Application No: FP/247/21/A
Site Address: 26 Felpham Road Felpham PO22 7AZ
Description of works: Installation of 1 No. externally illuminated fascia sign.

Thank you for your internet representation made on 22nd December 2021 which has been recorded as an objection with the comments as follows:

SOUTH ELEVATION

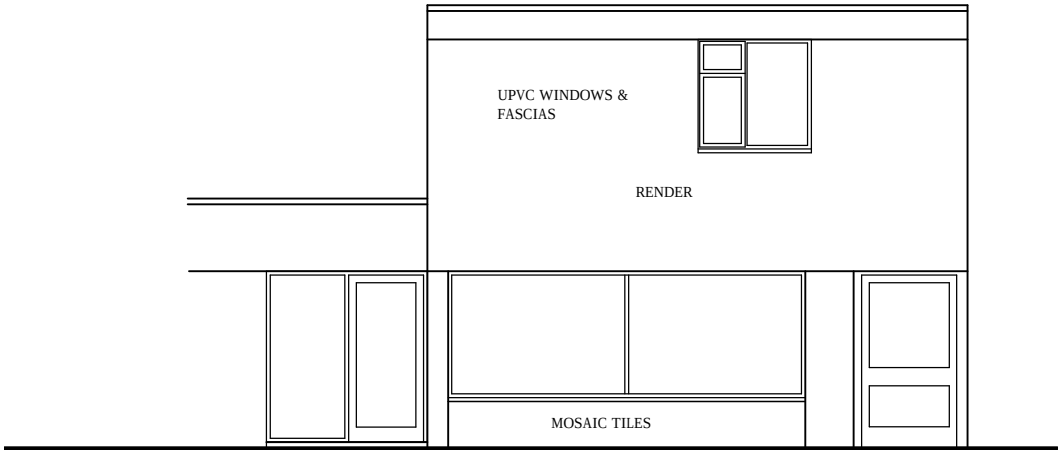
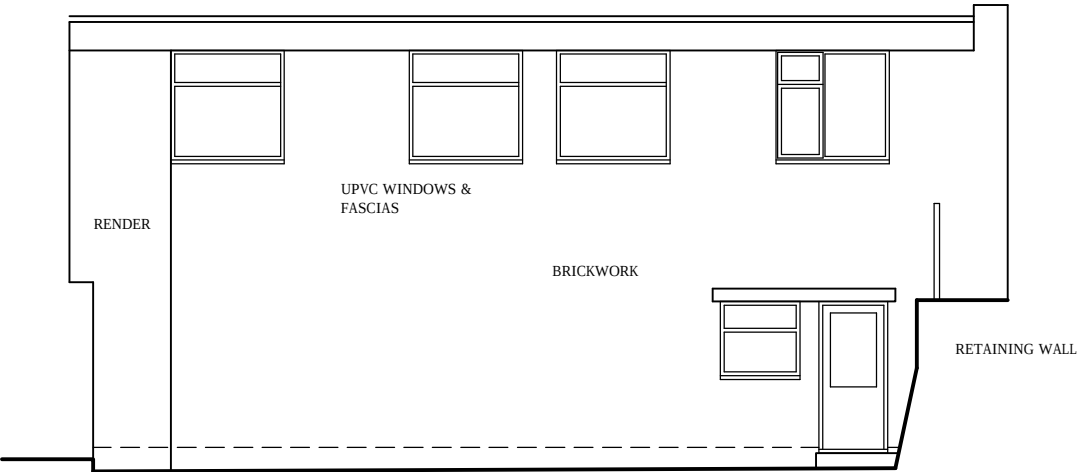
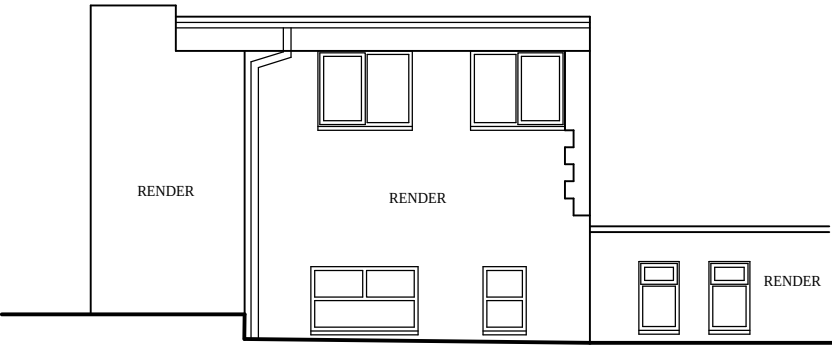
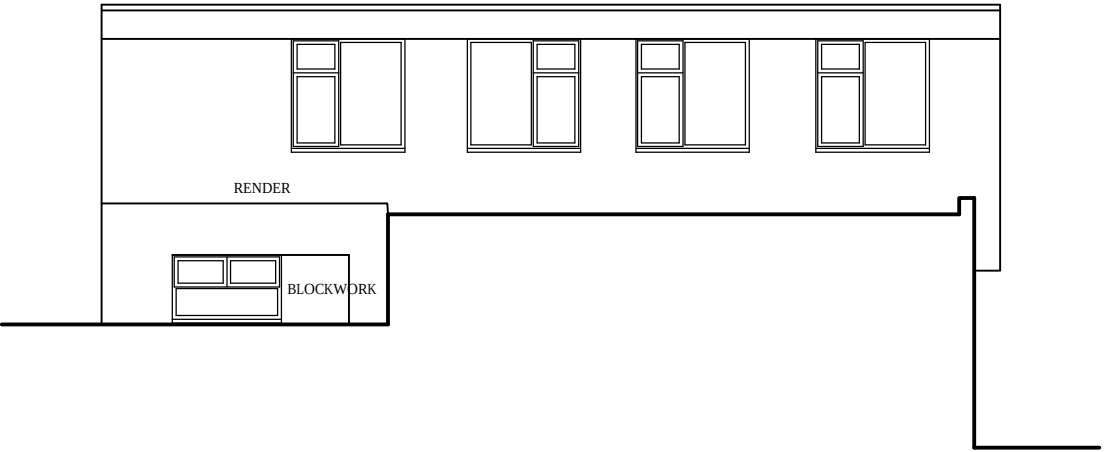
The proposed 'Caffe Grey's' kitchen and extraction machinery is too close (2-3 meters) to residential bedroom windows.

It is apparent that the proposed extraction is not sufficient for this type of commercial cooking.

Admiralty House's windows are directly behind the proposed ducting and prevailing winds. This is inappropriate.
